WEST SUSSEX COUNTY COUNCIL CONSULTATION

TO:	Arun District Council FAO:
FROM:	WSCC – Highways Authority
DATE:	7 May 2025
LOCATION:	Land South of Wandleys Lane Eastergate PO20 3SE
SUBJECT:	BN/46/25/PL Application for construction of 10 No dwellings with new access from Wandleys Lane, landscaping and areas for ecology & amenity space. This application is a Departure from the Development Plan and is in CIL Zone 3 and is CIL Liable as new dwellings.
DATE OF SITE VISIT:	n/a
RECOMMENDATION:	No Objection

**PROPOSED SITE PLAN
(1:200)**

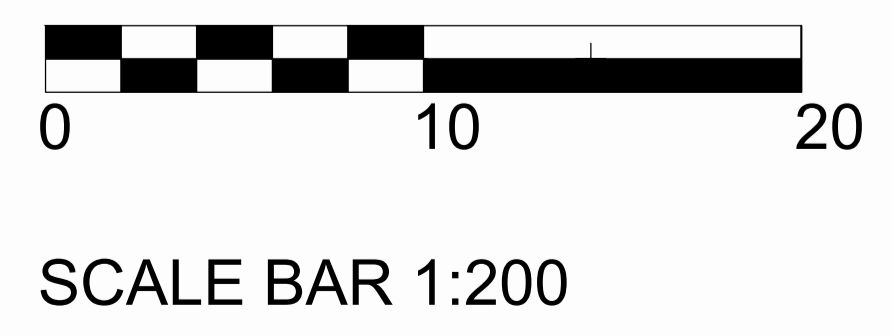
A new bell mouth access will be created onto Wandleys Lane providing visibility spays of 2.4m x 43m in both directions and are within the public highway. These are in line with the current speed of the road which has a posted 30mph speed limit.

The access road will be provided at 4.8m wide with a 6m kerb radii which will allow two cars to pass each other.

WSCC are please the developer will be providing a pedestrian footway from the site to link into the footway at Holmdale. Please can the applicant make sure the pedestrian visibility splays here are 43m in both directions. The internal footpath should also be provided with a width of 2m.

Sept Path Tracking – Refuse Freighter

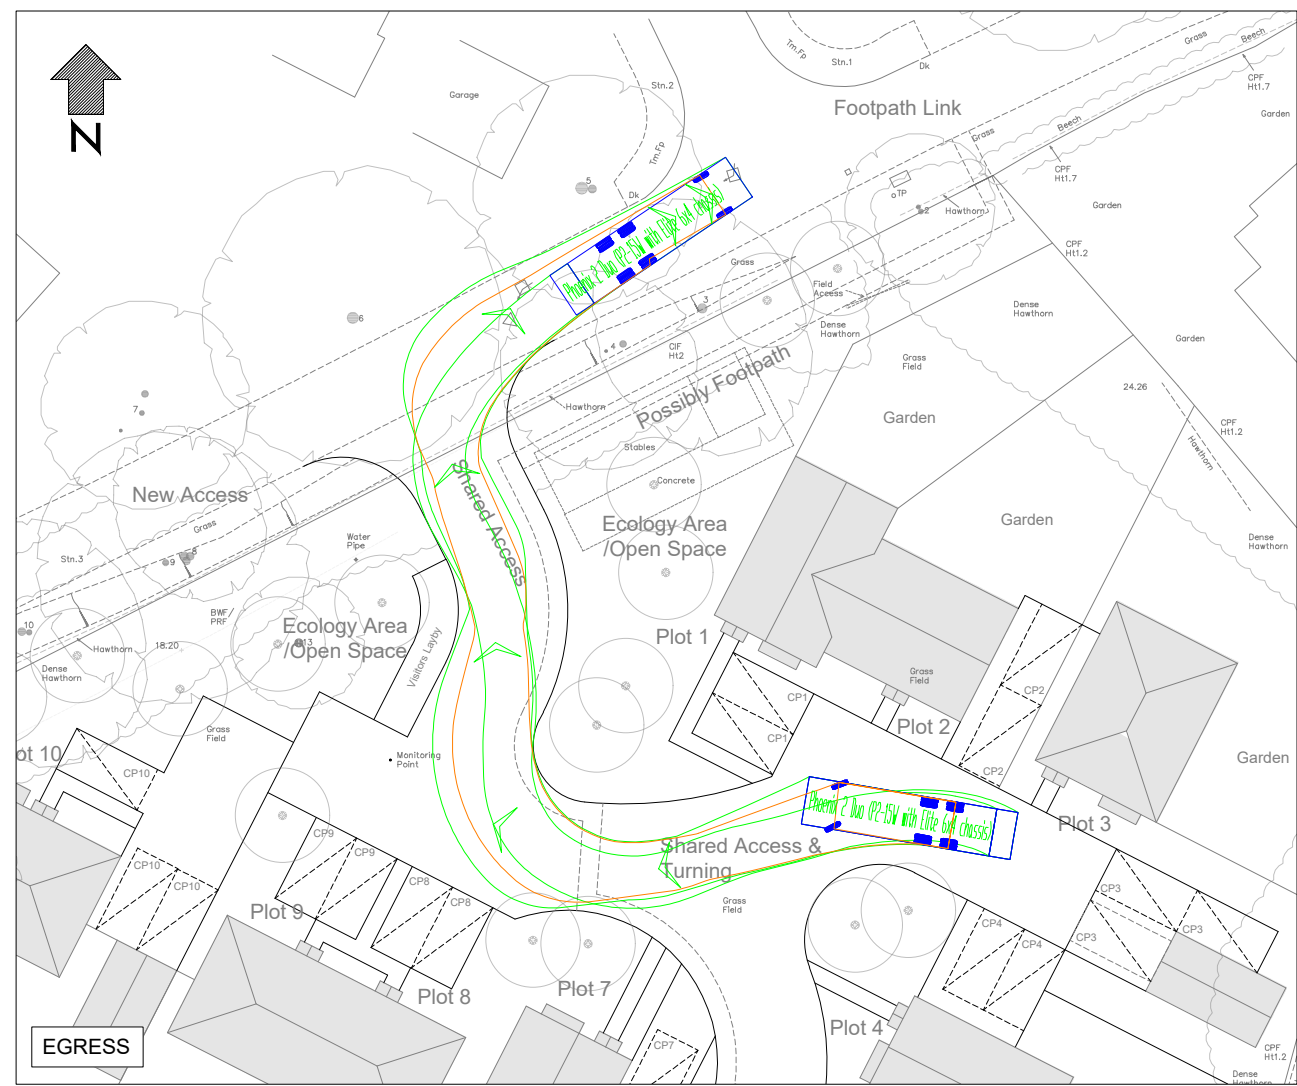
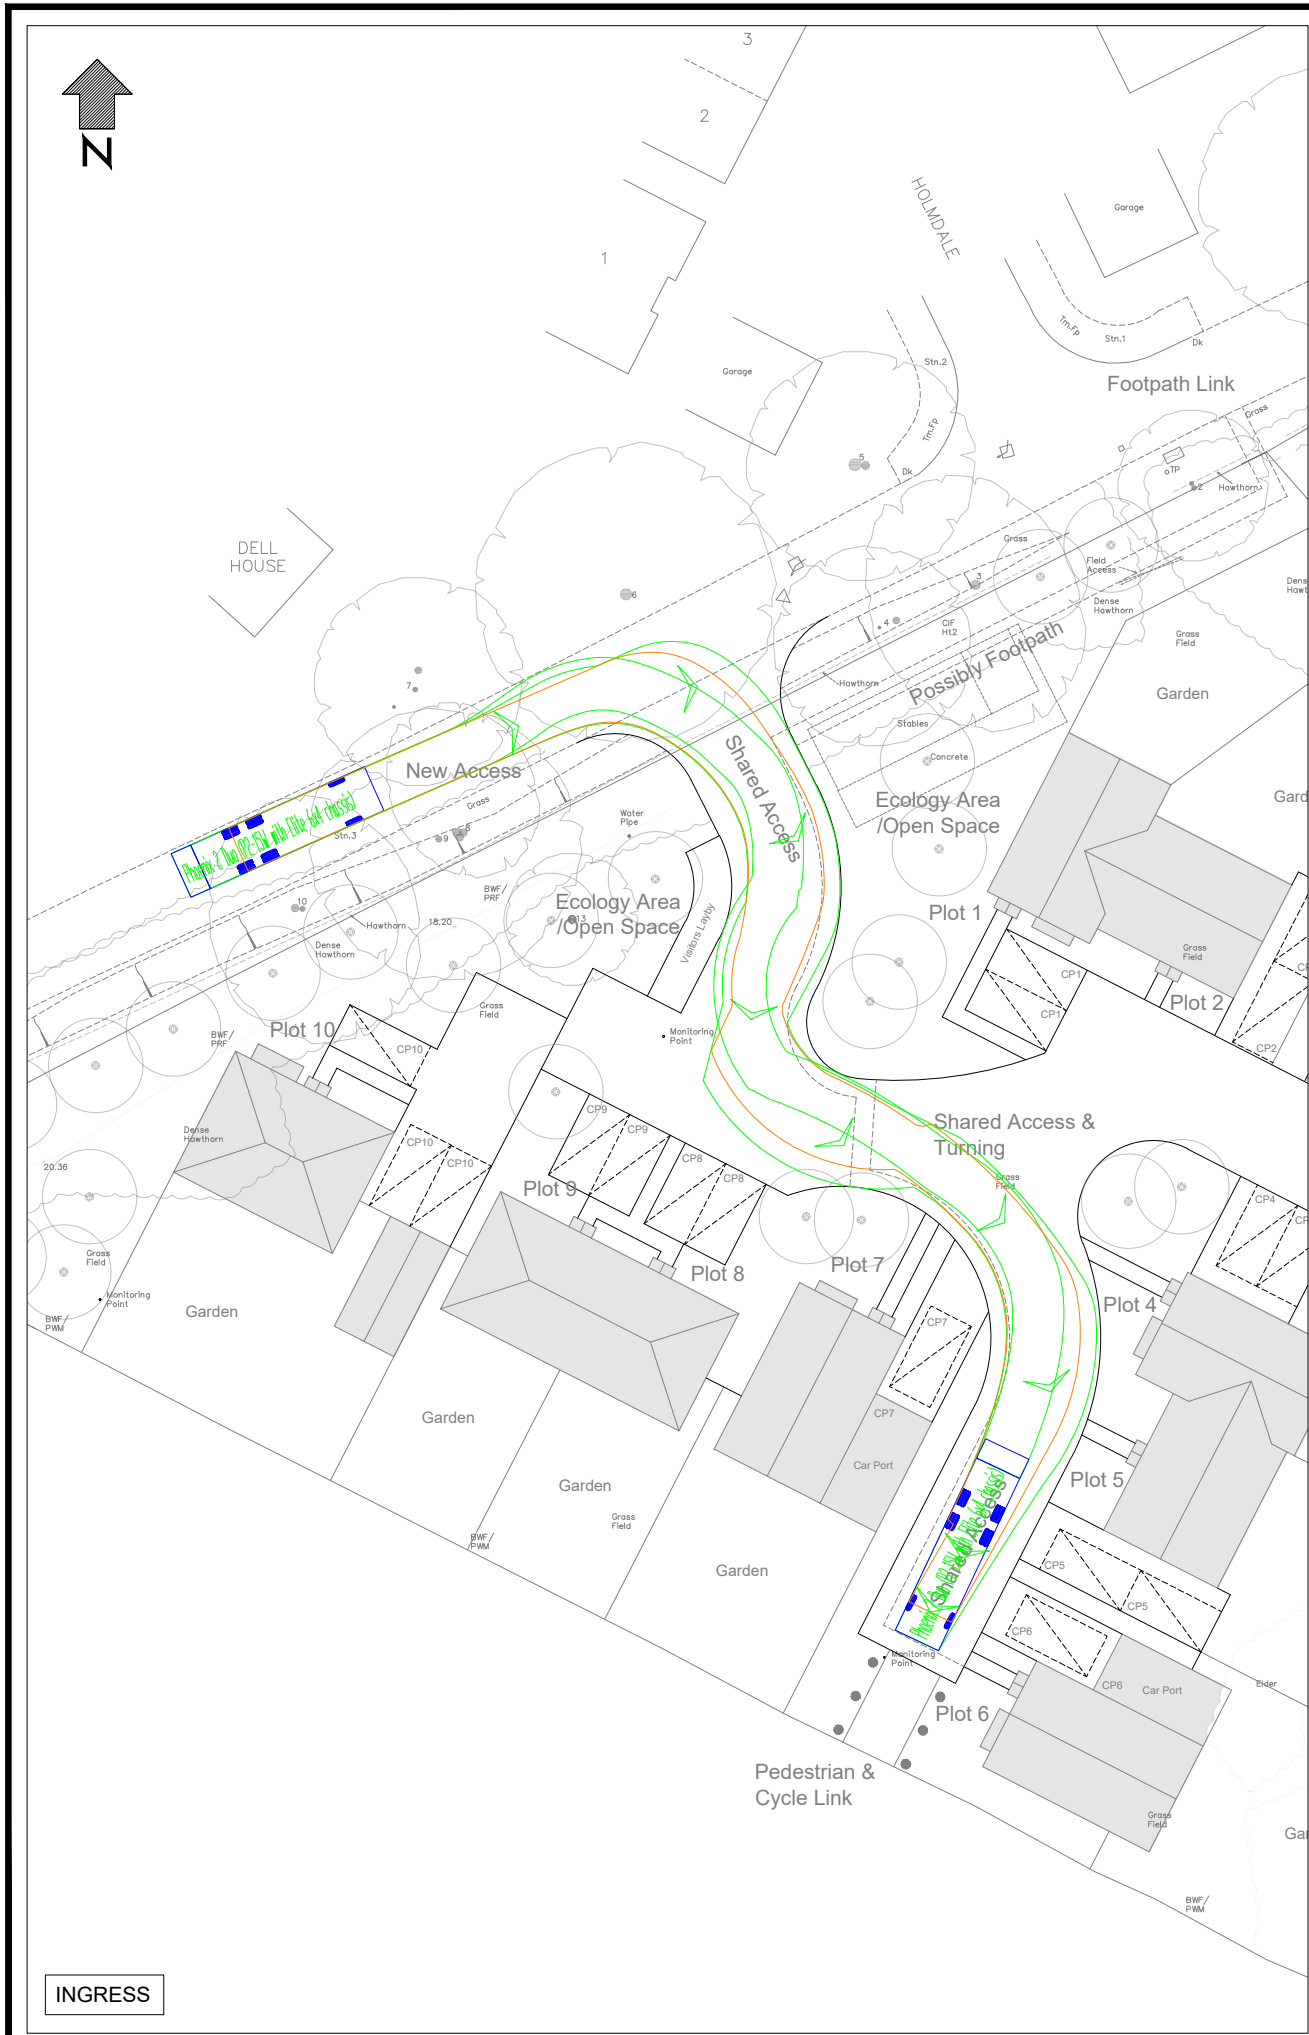
Swept path diagrams of a refuse vehicle, fire appliance and service delivery vehicle entering, turning and exiting the site from Wandleys lane, have been provided to demonstrate the layout can accommodate these movements.
